MEADOWBROOK CROSSING

A portion of the South 1/2 of Section 8, Township
14 South, Range 65 West of the 6th P.M.,
El Paso County, State of Colorado

MEADOWBROOK CROSSING
Date: 12/06/2016
Sheet 2 of 3
Project No: 160425
Drawn By: ZAR
Checked By: SLM

MEADOWBROOK CROSSING FILING NO. 1
Project No. 160425
Date: 12/06/2016
Sheet 1 of 3
Drawn By: ZAR
Checked By: SLM

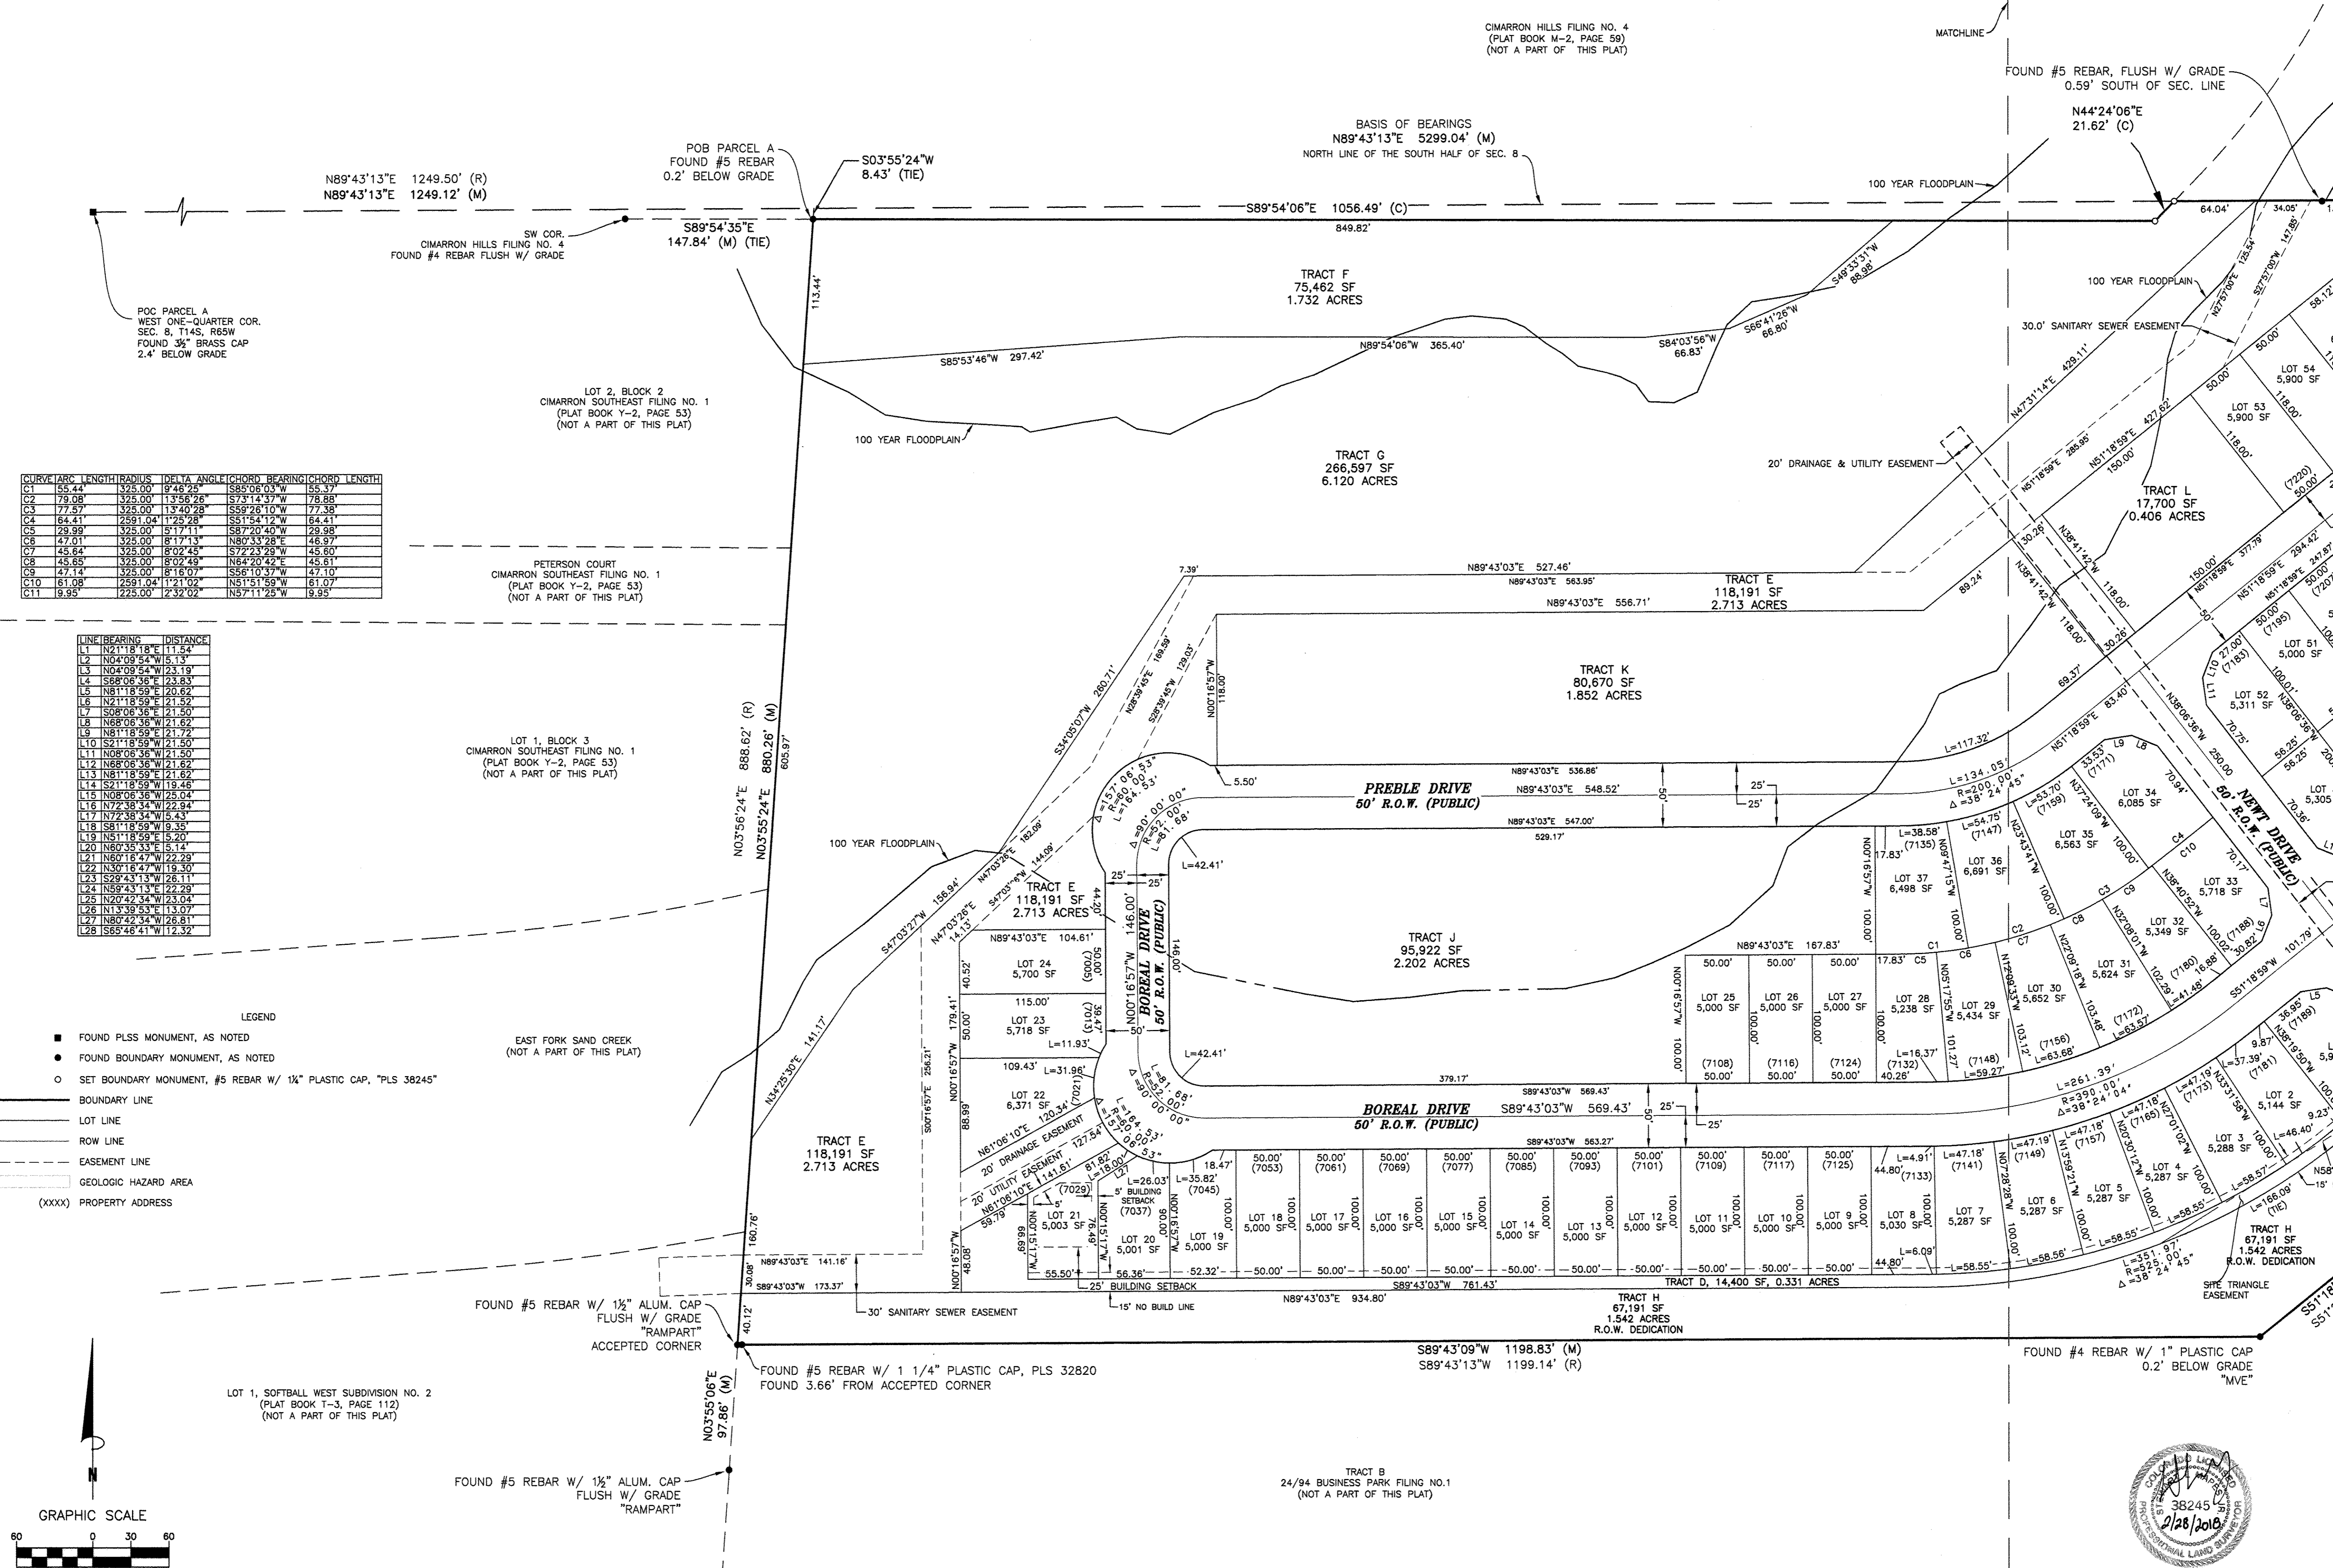
Preliminary Plan identifies Lots 25-31 and 46-52. Update both plans accordingly to match.

There is an urban park fee and a regional park fee. Please remove one block.

Does this include tracts? If so please break out tracts from row

MEADOWBROOK CROSSING FILING NO. 1  
Drawn By: ZAR  
Checked By: SLM  
Date: 12/06/2016  
Sheet 2 of 3  
Project No. 160425

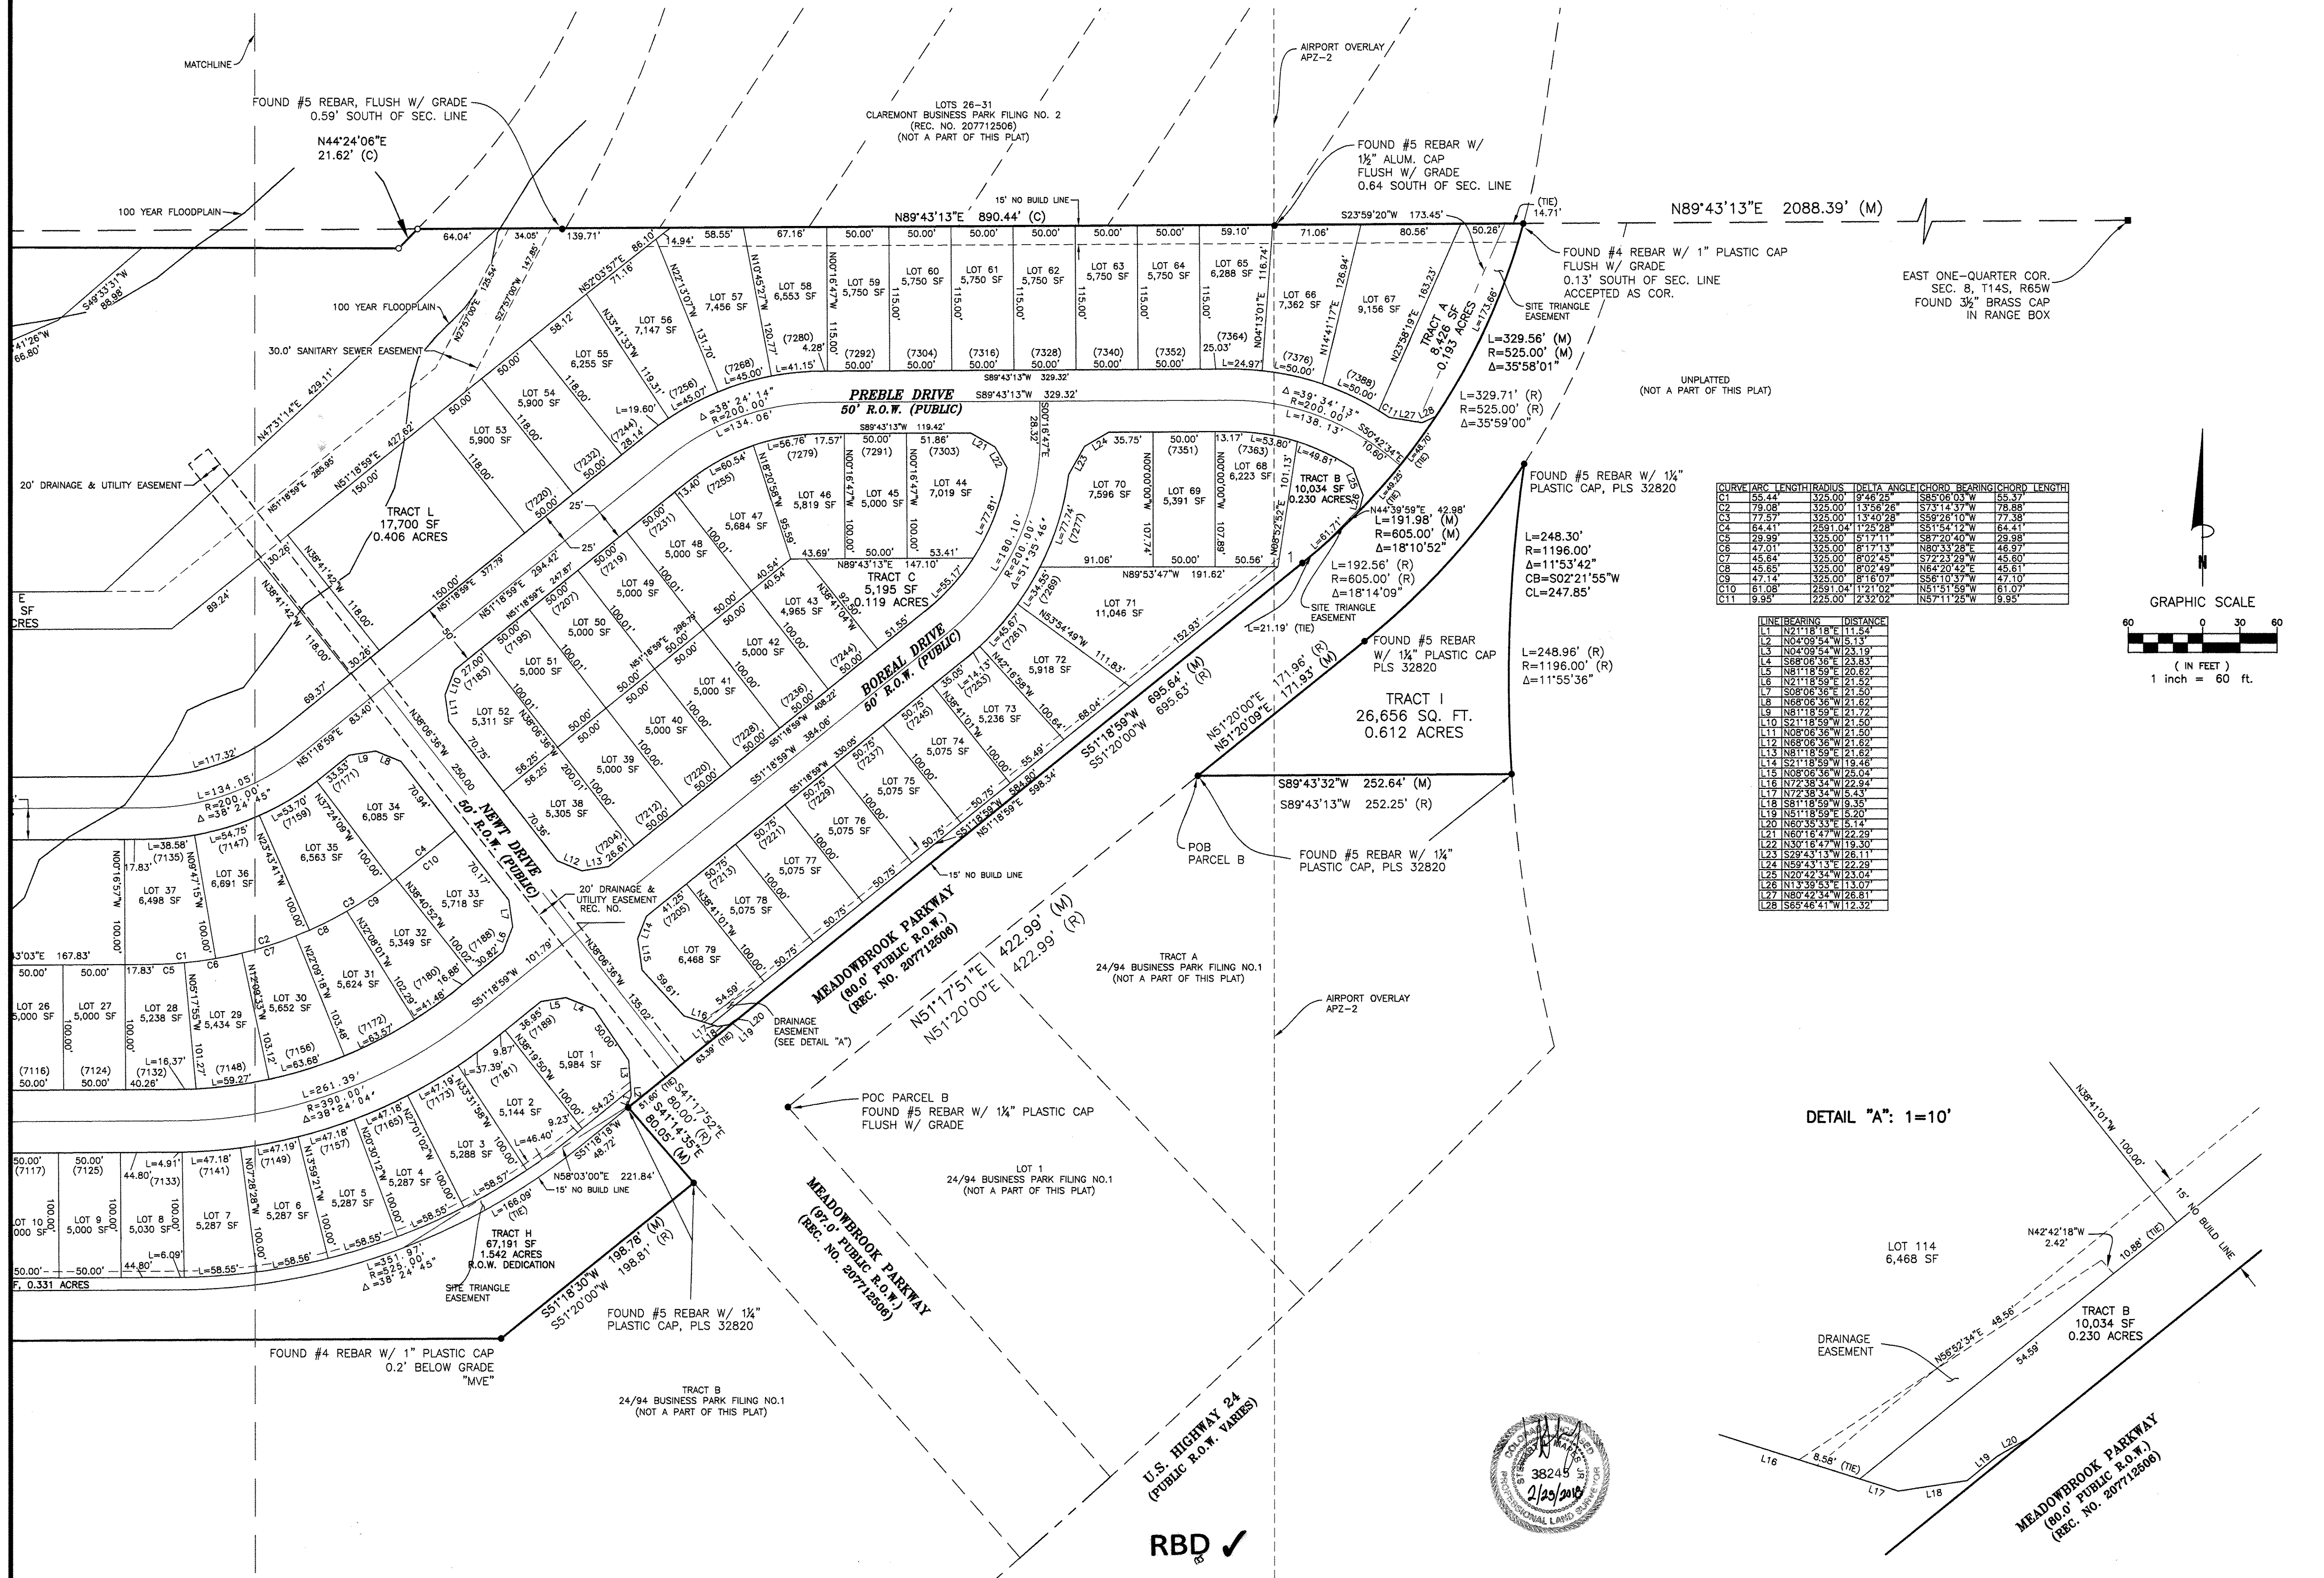
Darken /
lightweight Plat
Boundary so it is
clear what the
legal description is
describing.

buffer line (who install landscape?
please reference the landscape
plan and how it is going to be
implemented. (see LOL comments)

Add the airport
overlay that precludes
SF development.
Match the preliminary
plan.

This is not being platted as parcel A or B please remove both.

Delineate plat boundary

This is not being platted with this. identify not a part of this plat. Comment pertains to all labels not included in this filing.
